Tracy Bellamy - Epping to Thornleigh Third Track Proposal. Application number SS1 5132

From: "Kay Martyn" <ksmartyn@bigpond.com>
To: <plan_comment@planning.nsw.gov.au>
Date: 2/11/2012 8:40 AM
Subject: Epping to Thornleigh Third Track Proposal. Application number SS1 5132
CC: <office@hazzard.minister.nsw.gov.au>, <philip.ruddock@aph.gov.au>, <office@smith.minister.nsw.gov.au>

Figure S.5 Artist's impression of new elevated concourse at Cheltenham Station looking south from The Crescent (indicated by dot)

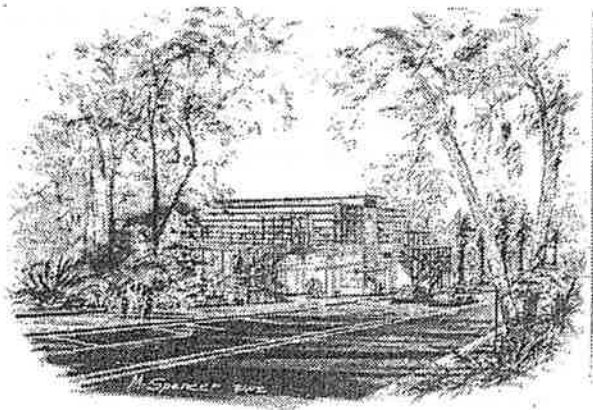
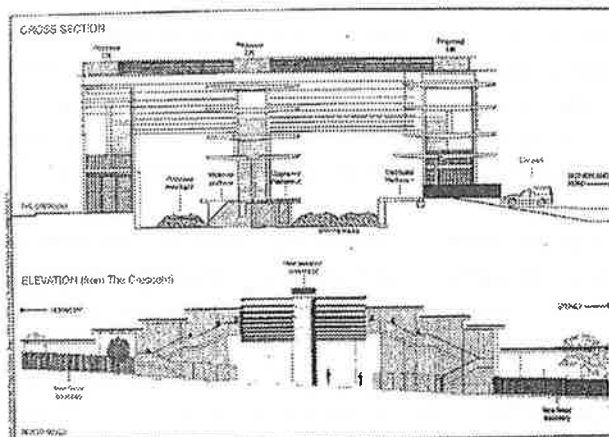
- b. The proposed redevelopment of Cheltenham Station shows no regard for the heritage conservation area. The visual impact of the proposed 13 metre high glass and steel concourse is totally unacceptable in this heritage conservation area.

Figure 5.3 Future Cheltenham Station layout

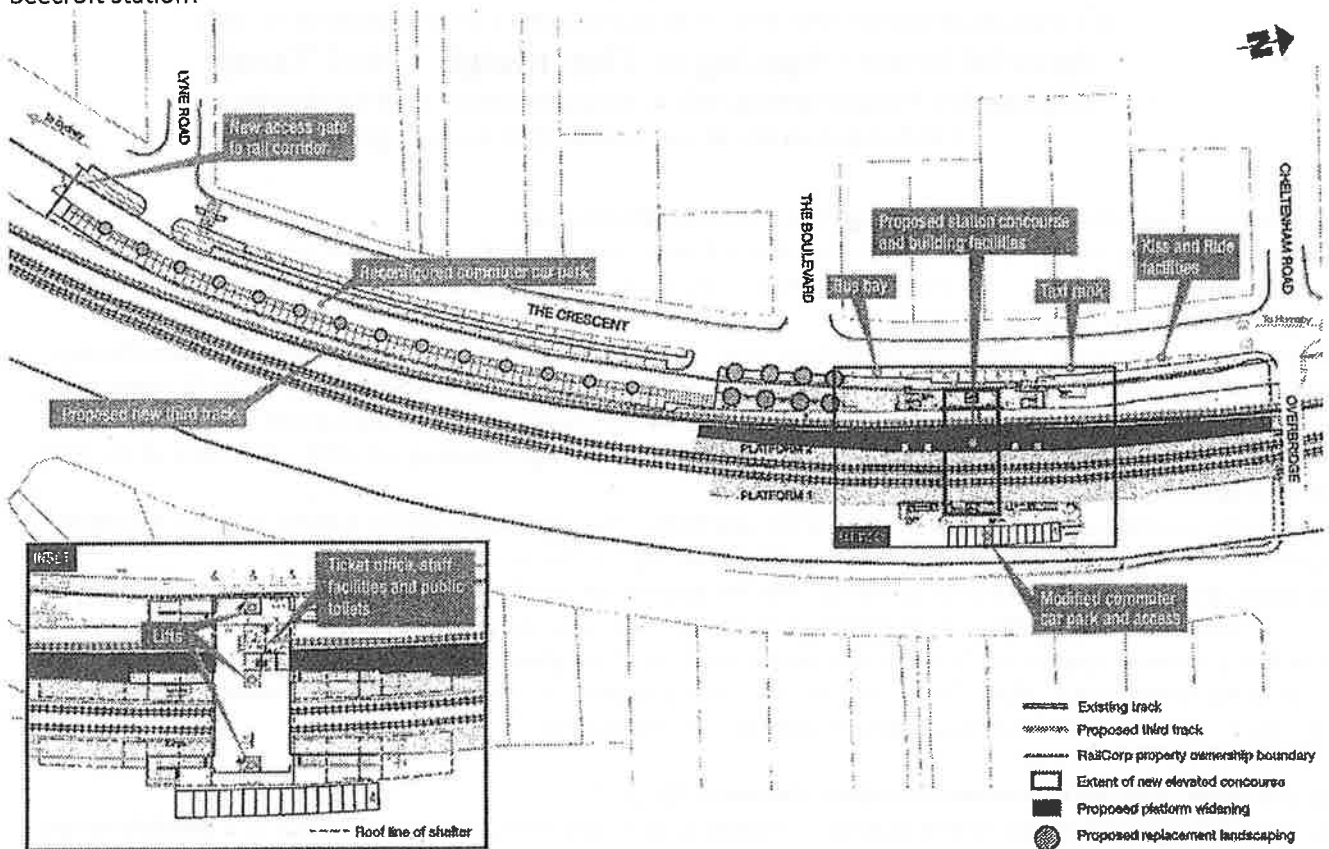
- a. The plan given for Beecroft Railway Station Precinct is vague. The relationship to the trees, playground and original 1895 platform located south of the present station is not shown. Beecroft Station Gardens have a heritage listing with Hornsby Council but the impact on them has not been adequately addressed. No arborist's report is given for the trees which will be removed.
